Please ask for: Mrs D Johnson
Email: daun.johnson@arun.gov.uk
Telephone: 01903 737762
Our Ref: LY/21/24/PD
Your Ref:
Date: 21st November 2024

Development: Prior notification under Schedule 2, Part 3, Class Q to change use of existing agricultural building to 1 No. dwelling house.

Location: Broomhurst Farm Lymminster Road Lymminster BN17 7QQ

GROUND FLOOR PLAN AS PROPOSED 1:50

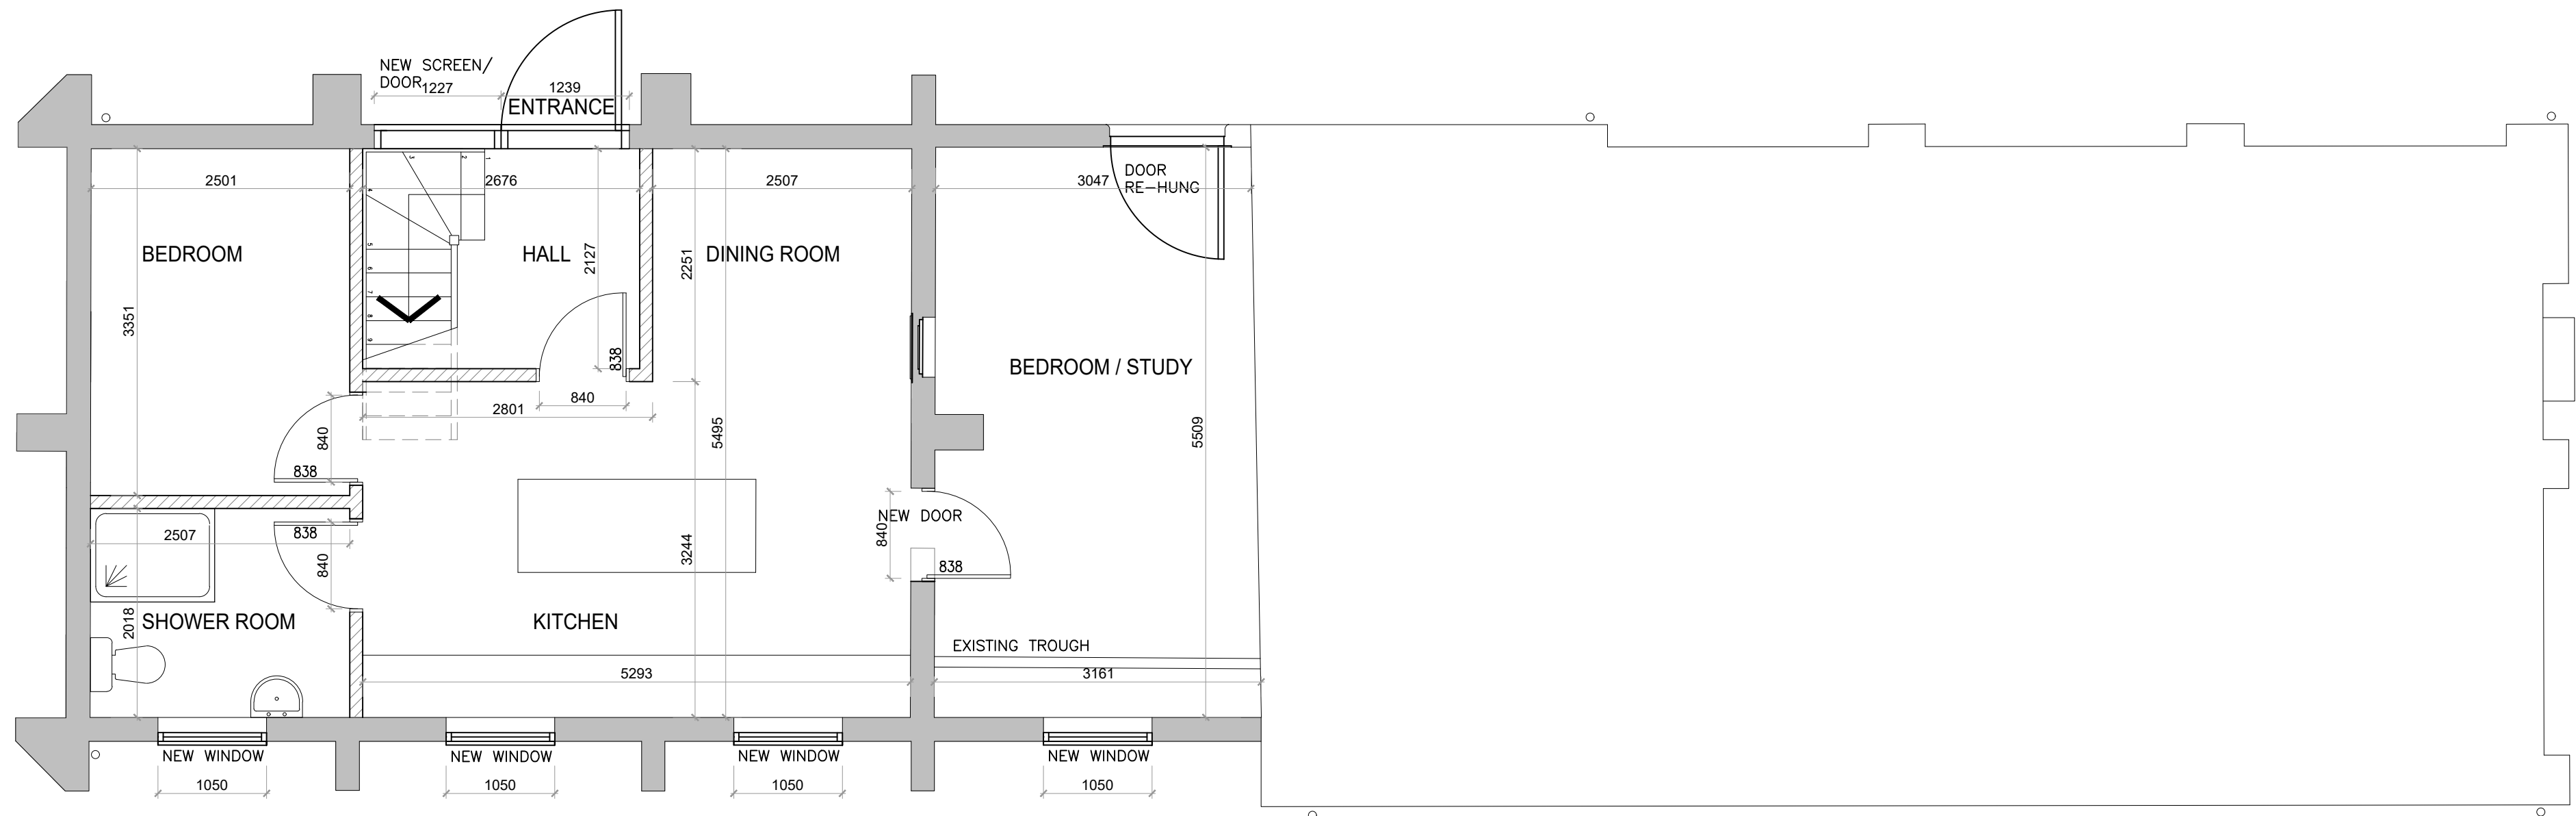
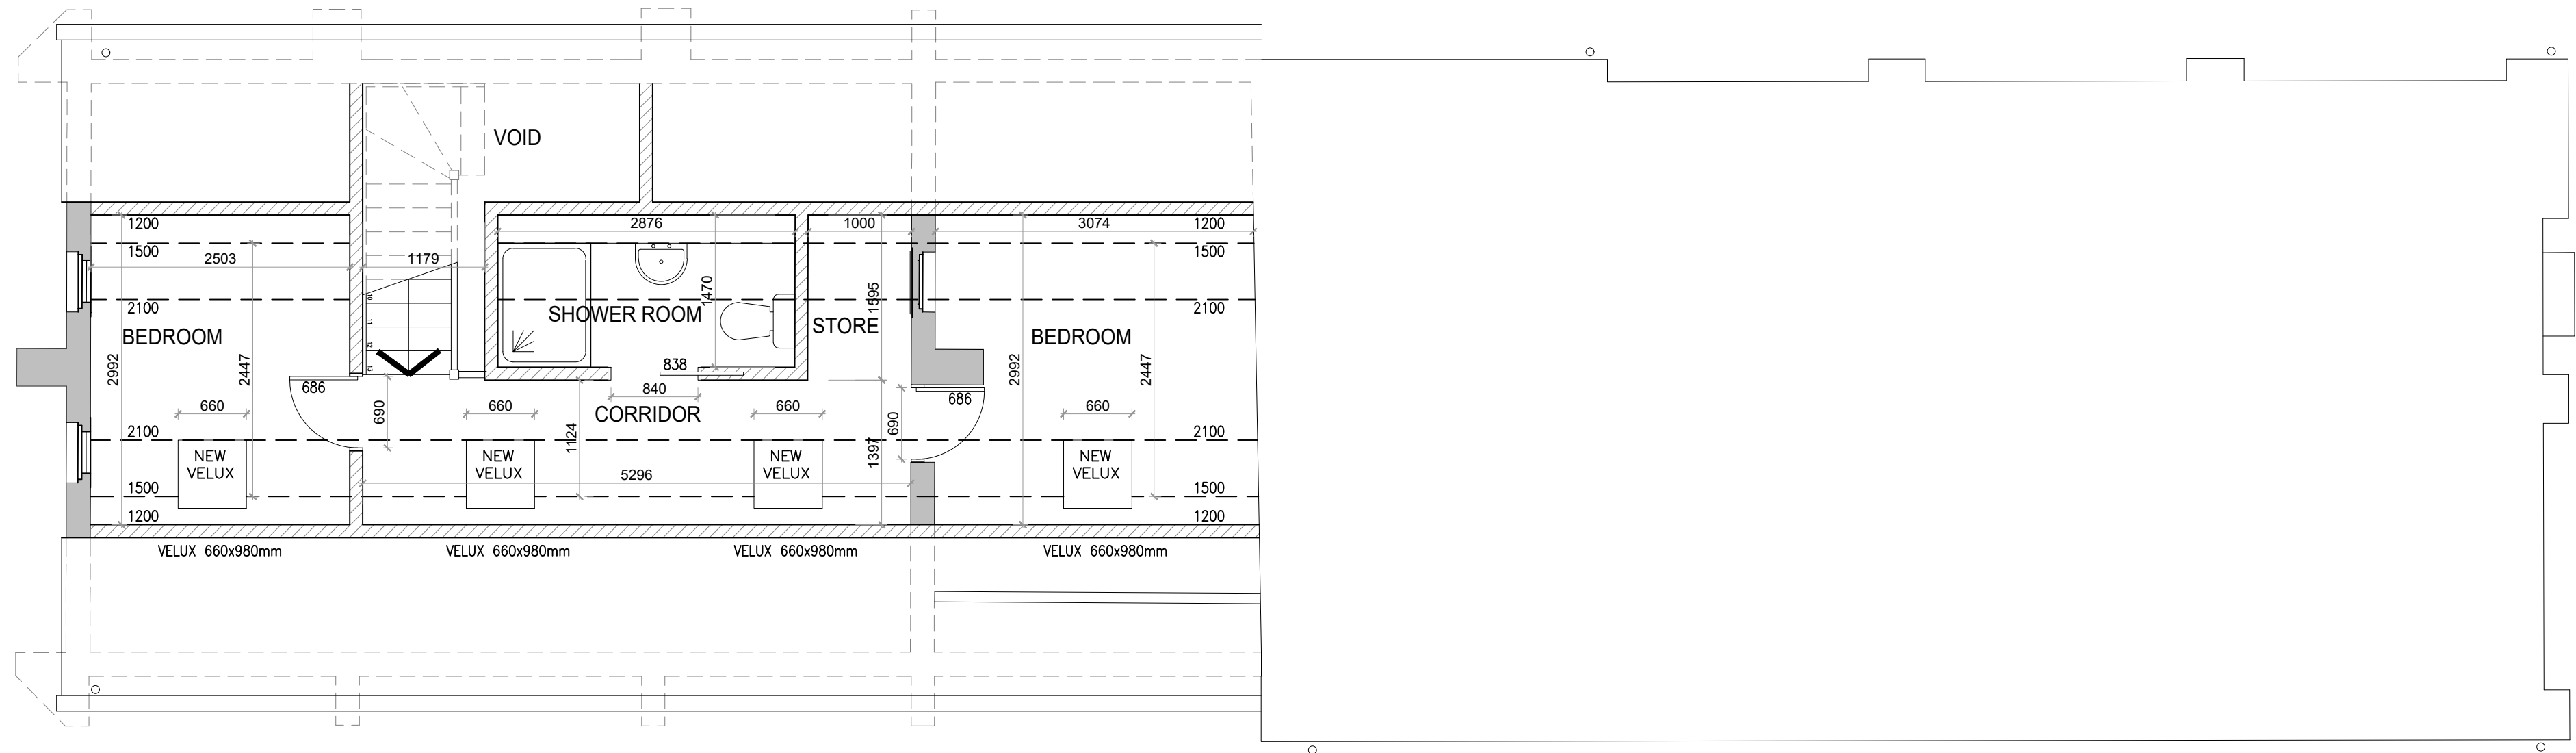
On the proposed floor plan, please provide dimensions of all doors and windows and dimensions of each room.
